From: Contact Centre (CRM) <contact@ribblevalley.gov.uk>
Sent: 08 April 2026 15:16
To: Planning
Subject: Planning Application Comments - Application 3/2026/0247 FS-Case-824442471

Planning Application Reference No.: Application 3/2026/0247

Address of Development: Spout Farm

Spout Farm

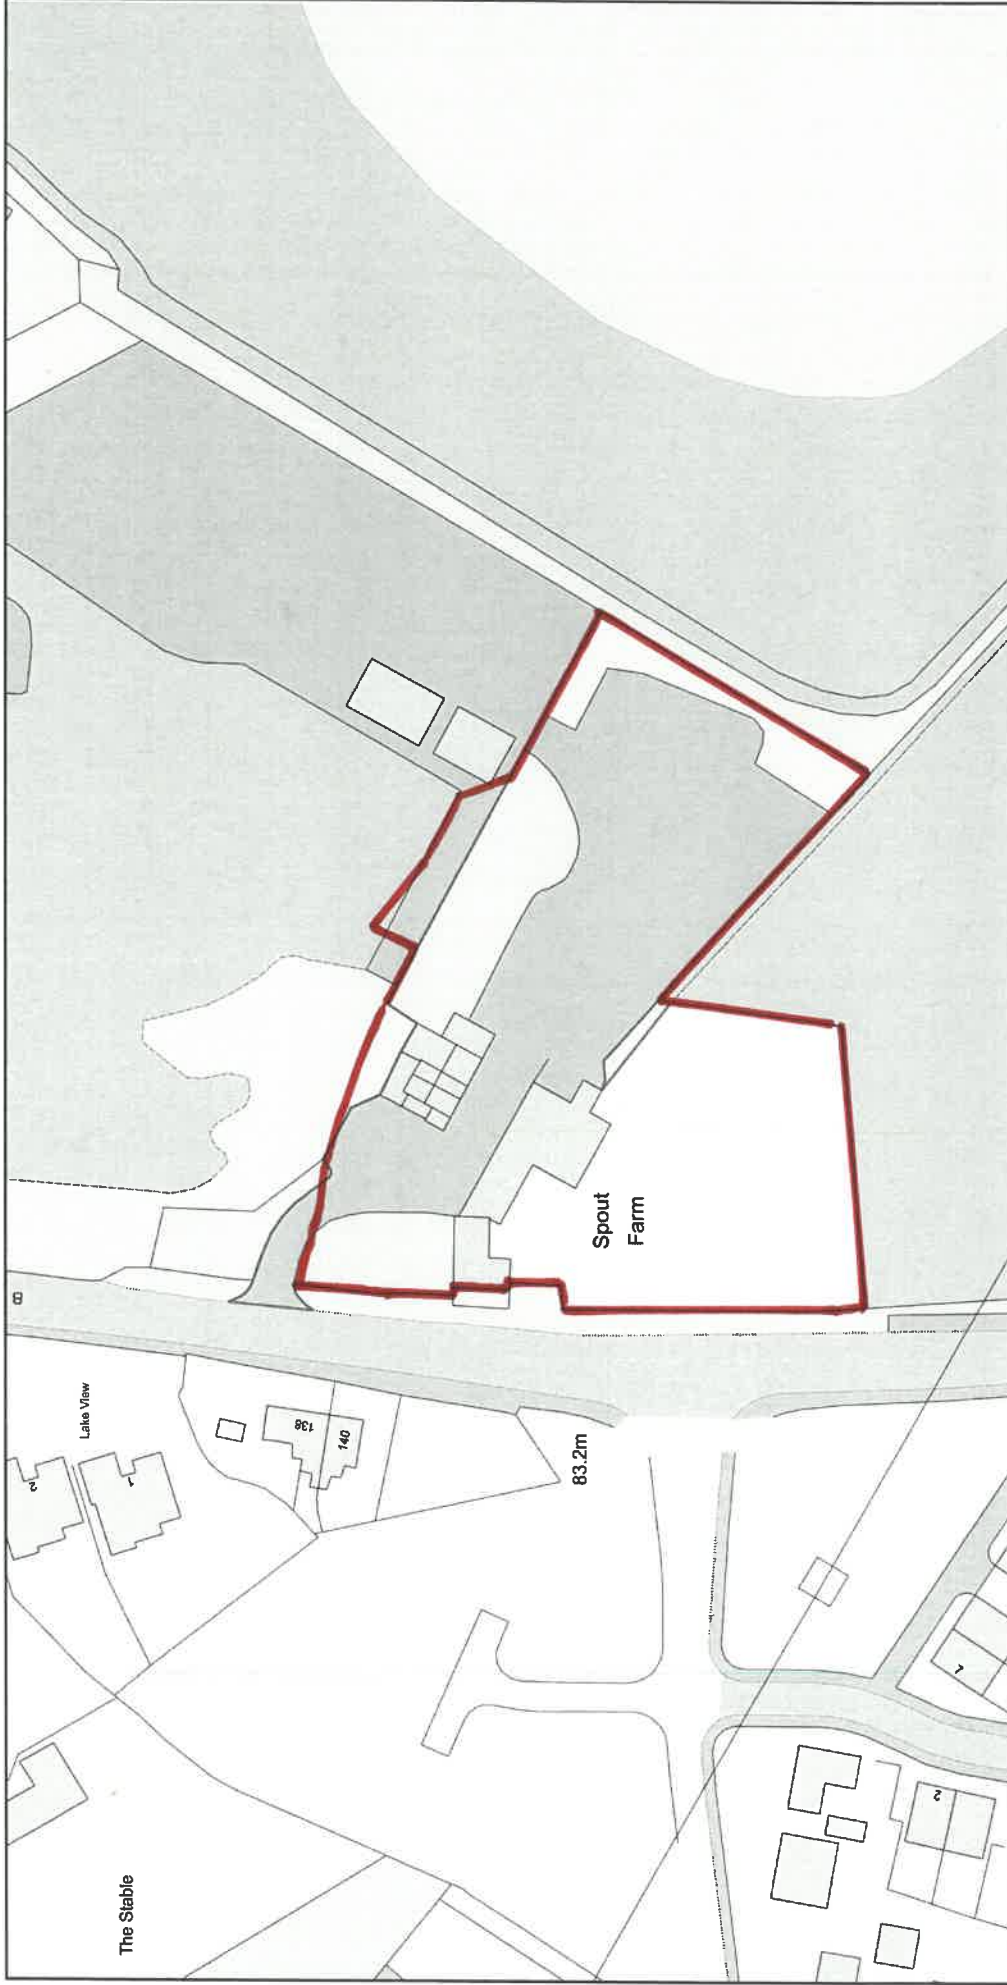
The outline red site location plan is incorrect and encroaches on land owned by the Sandpipers development. Please see title deeds with reference LAN 242913 which shows the Sandpipers boundary.

Reference to the Sandpipers own site planning and approval 03/2020/0309 which, contradicts the location plan submitted on this new application - see point 2.1 above.

Reference to The Sandpipers estate approved application 3/2020/0309, to the north of the new application 3/2026/0247. If the location plan of application 3/2020/0309 is compared to application 3/2026/0247 you will see that there is a contradiction in boundaries. Subsequent Land Registry title LAN242913 shows the applicant does not own the land directly in front of Plot 34, 33 and 32 of The Sandpipers estate. This is in fact shared access to these plots and an area of public open space.

2. Figure 1. Of the PiP (Page 5) shows the current red line plan issued with the application. On review of the previous planning application (3/2020/0309) and the proposed site plan within this application, it is clear that the boundary put forward within the most recent PiP application encroaches on the site not under the control of the applicant.
